Subject: RE: BN/150/21/HH - 1 Bateson Way, Barnham

BN/150/21/HH

BN/150/21/HH at Bateson Way, Barnham.

BH/BW/03

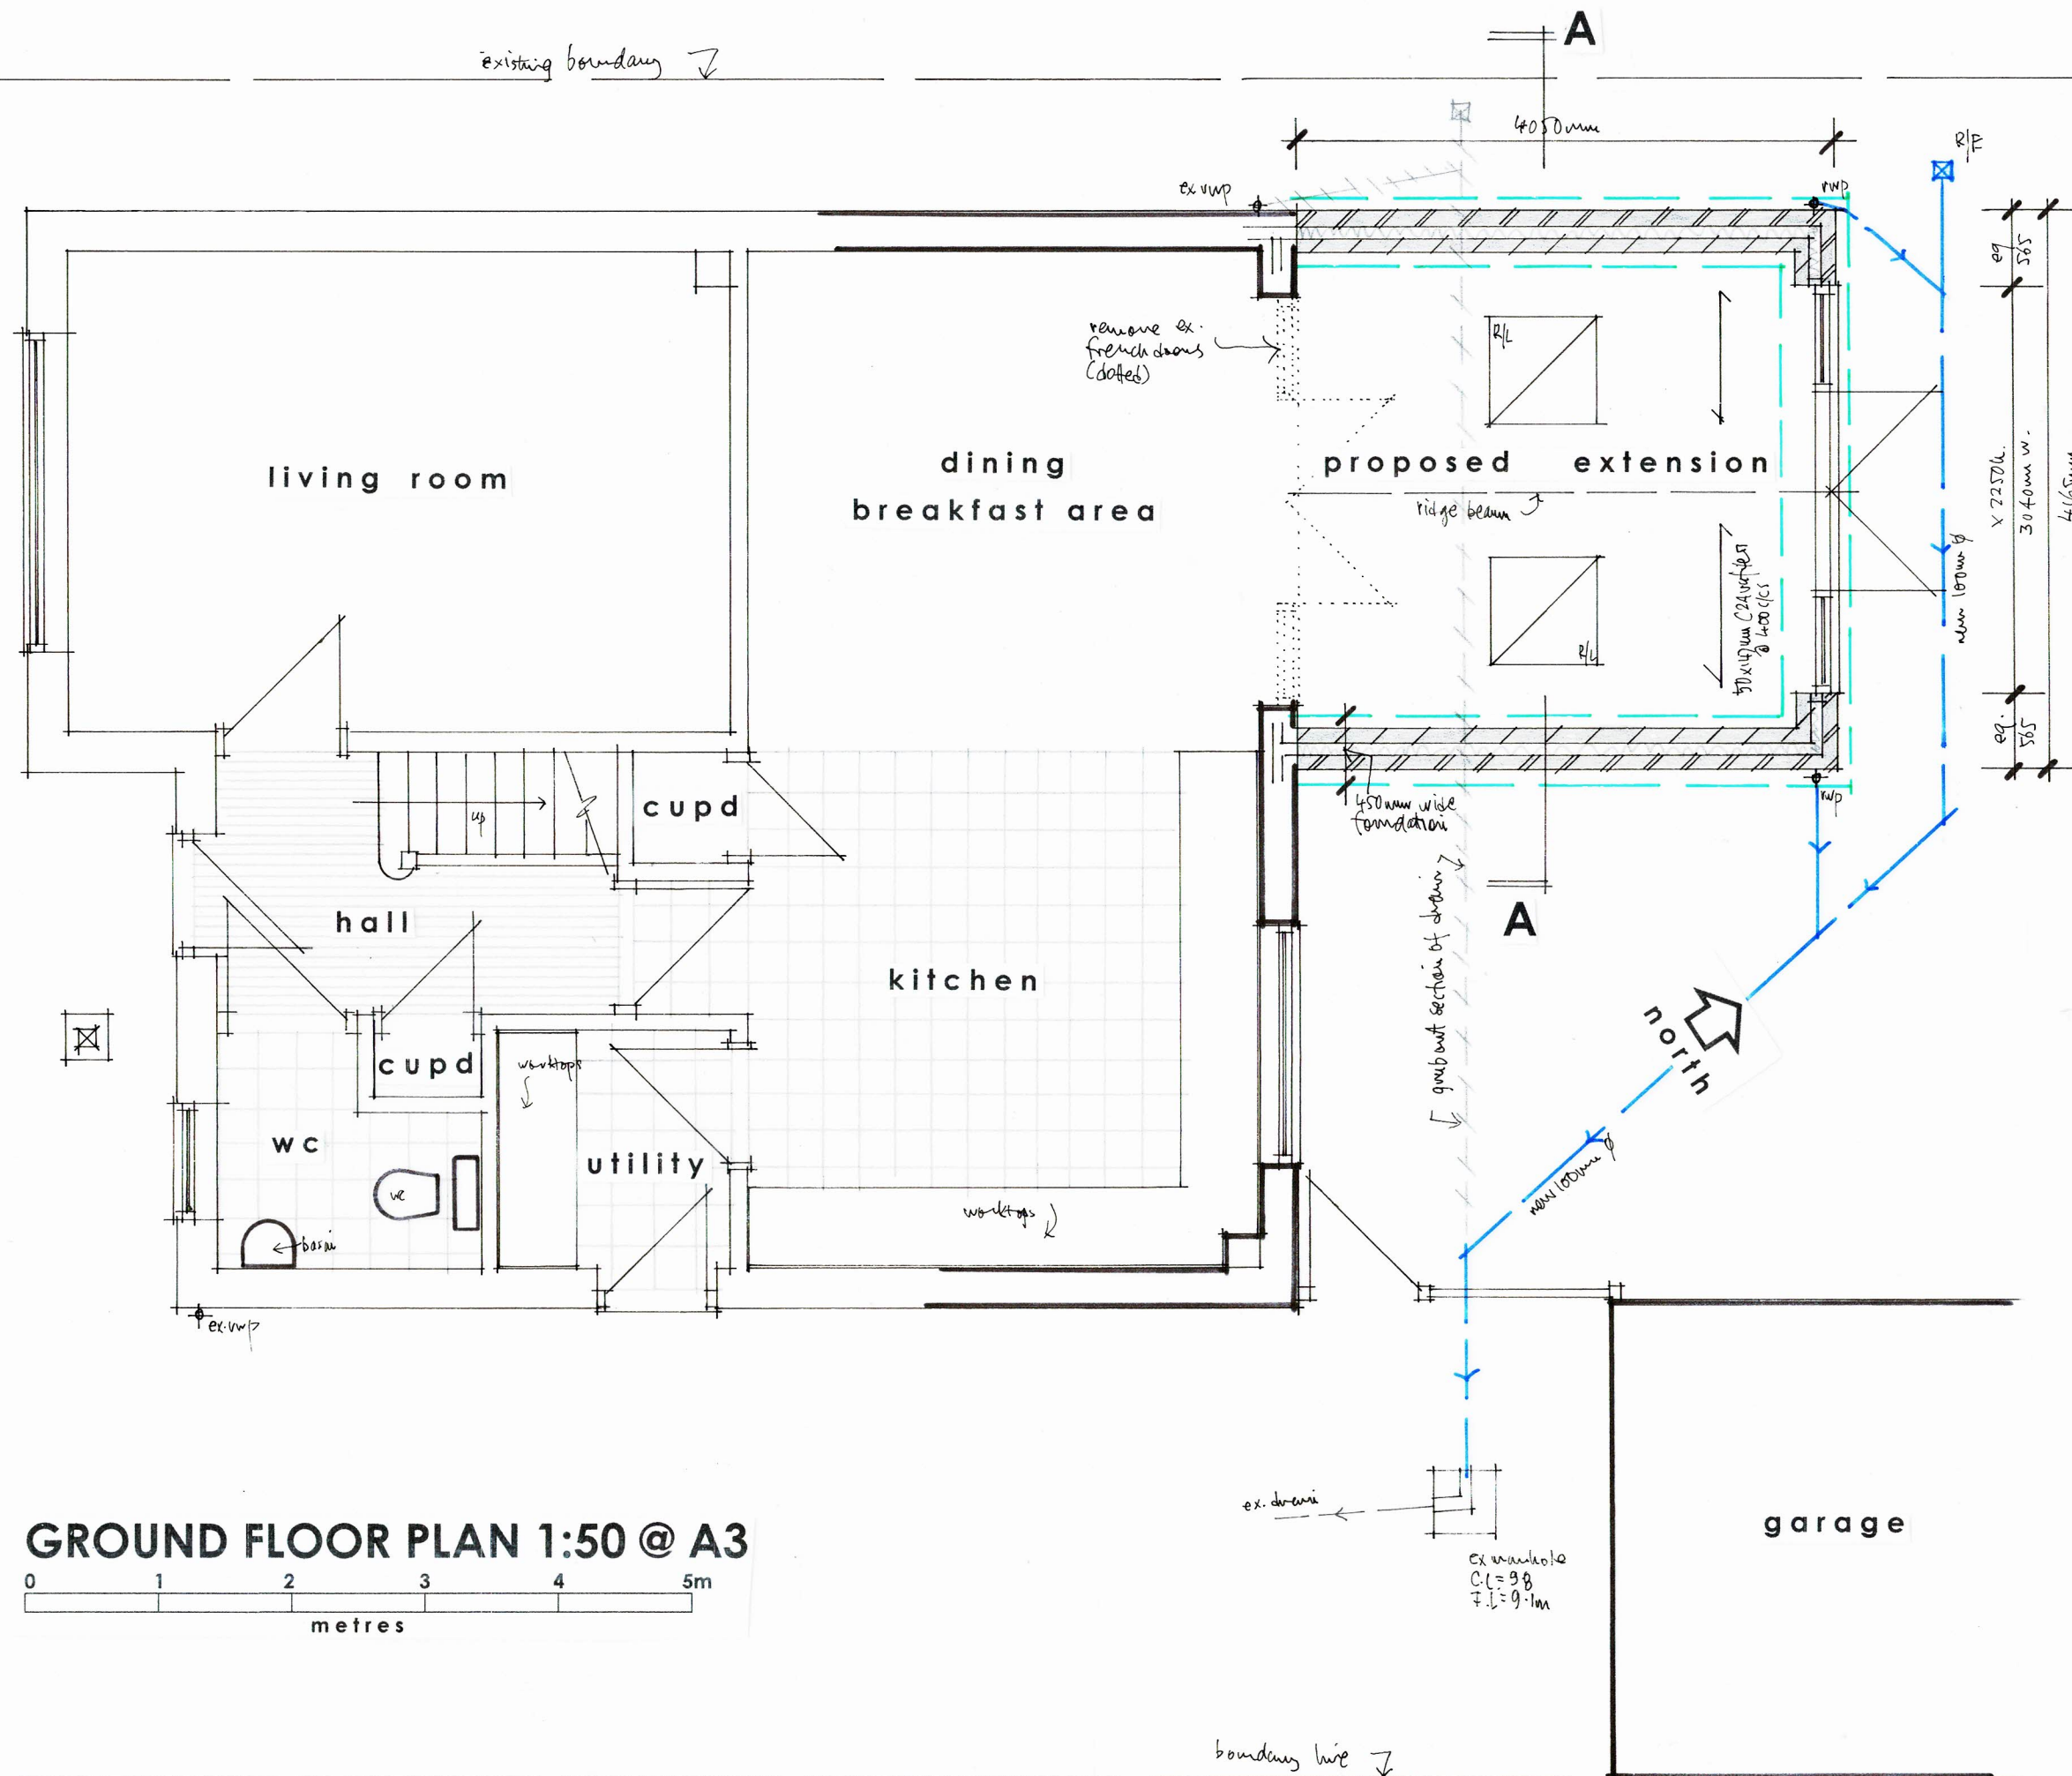
On the basis of Drawing BH BW 03A – which I would like uploaded to the portal. I ask that my request for the application to be conditioned is disregarded. Surface water drainage must be constructed in accordance with said drawing.
